## Application for a Non-Material Amendment Following a Grant of Planning Permission

demolition of the existing dwelling and erection of a two storey plus lower ground floor level detached dwellinghouse with integral garage, associated refuse/recycling store, cycle store, amenity space and provision of 2no.off street parking spaces

22/0501/ful

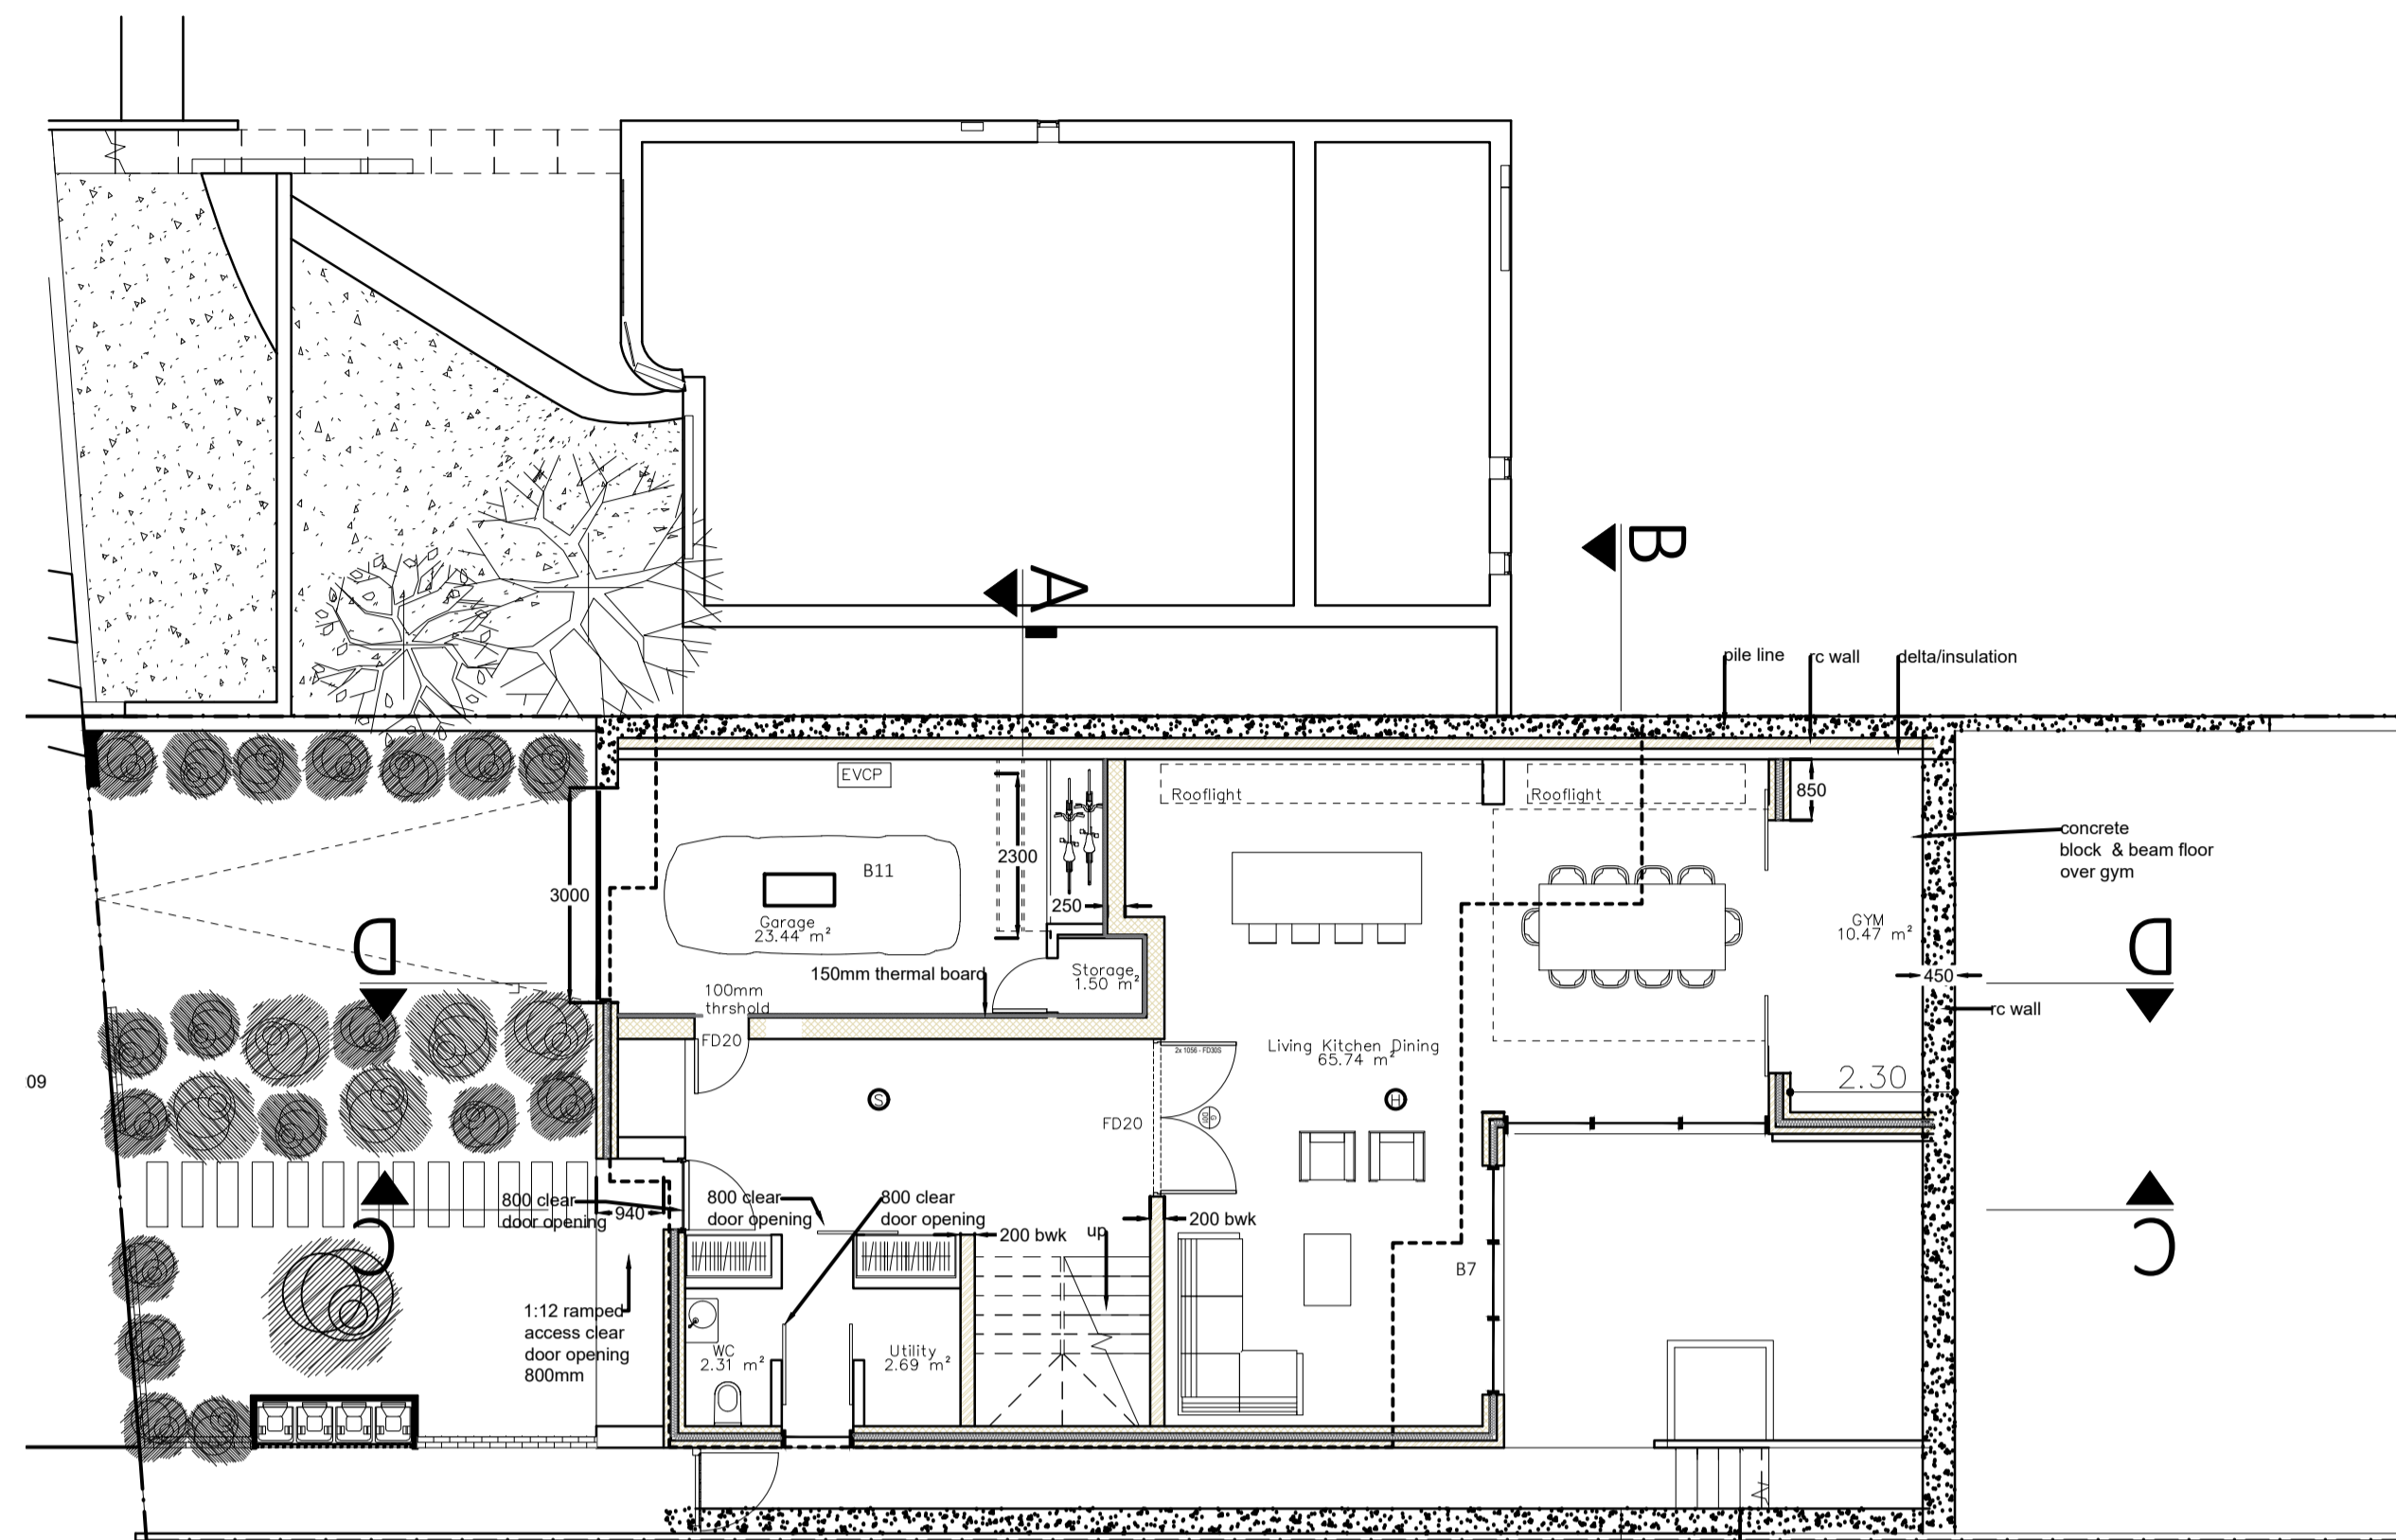
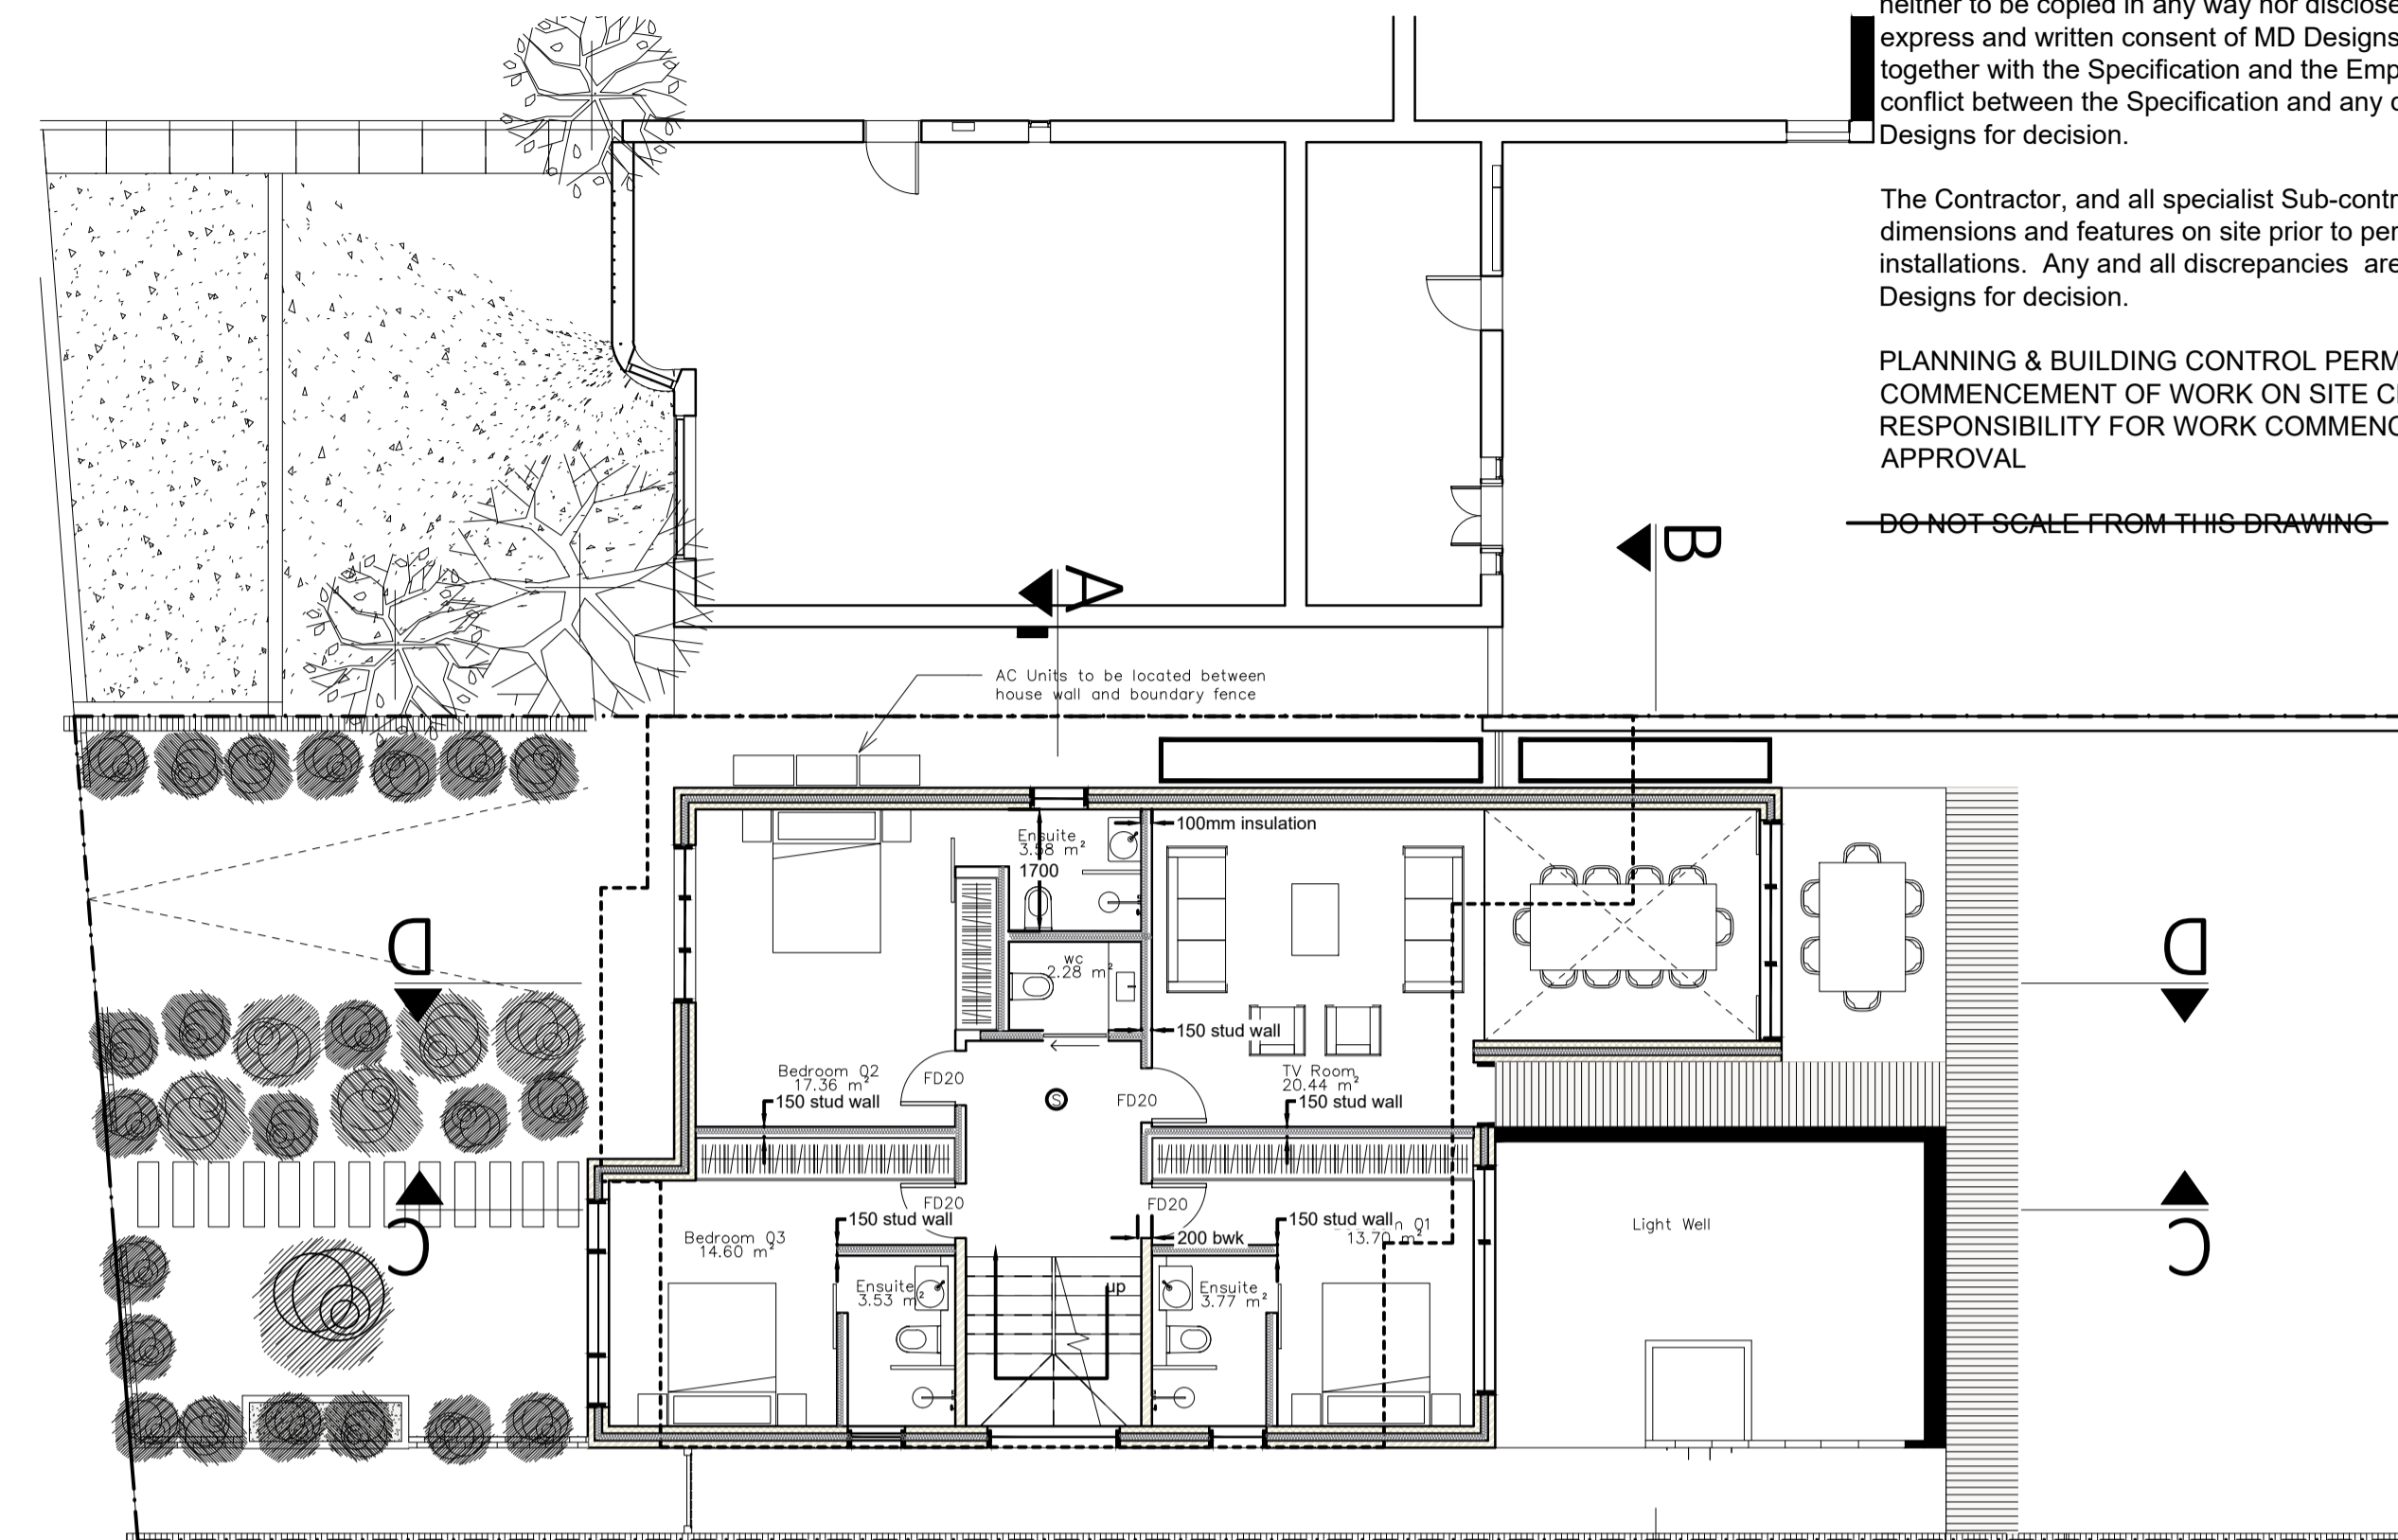
the back addition part of the build has been extended by 500mm

to rectify the build
